Our reference: ECM: 9030810
Contact: Gavin Cherry
Telephone: 4732 8125

2 March 2020

**SSD 7733 – Further Comments Following Teleconference - Penrith
Resource Recovery Facility at 46 Peachtree Road Penrith**

01 PROPOSED SITE PLAN
SCALE 1:500

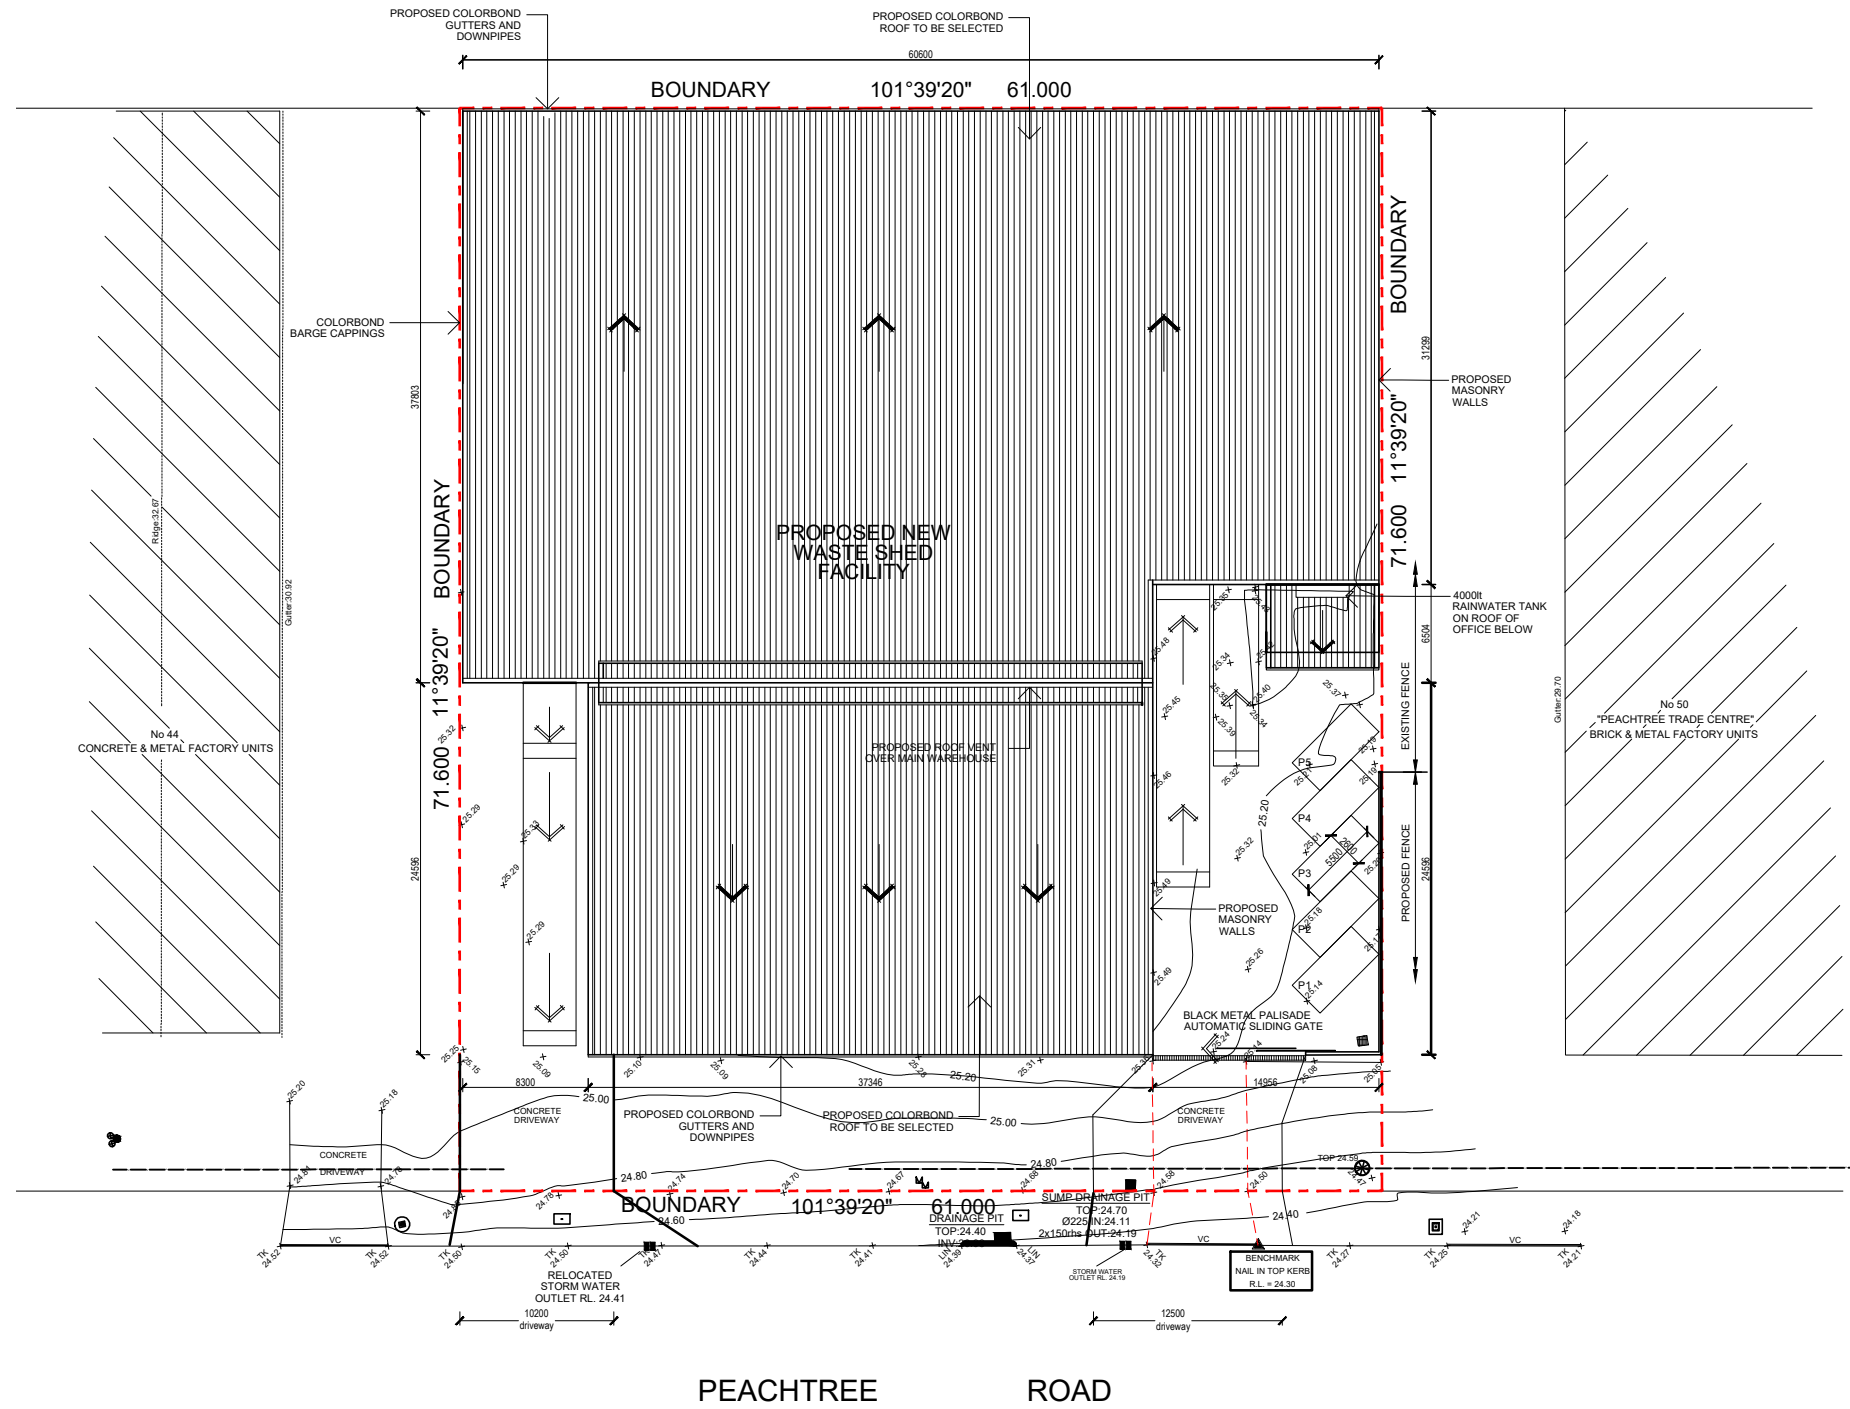
Council maintains its position that the driveway must be widened to satisfactorily facilitate truck turning swept paths clear of parking lanes, and clear of oncoming vehicles in opposing travel lanes. Amended plans reflecting this requirement should be submitted that demonstrate compliance with this requirement.

The application appears to now indicate that no formalised truck parking is line marked to be provided. It must be demonstrated that sufficient space on the site is available to accommodate sufficient on-site truck parking. It is not sufficient to remove indications of parking without demonstrating that parking is available, without reliance on the local road network.
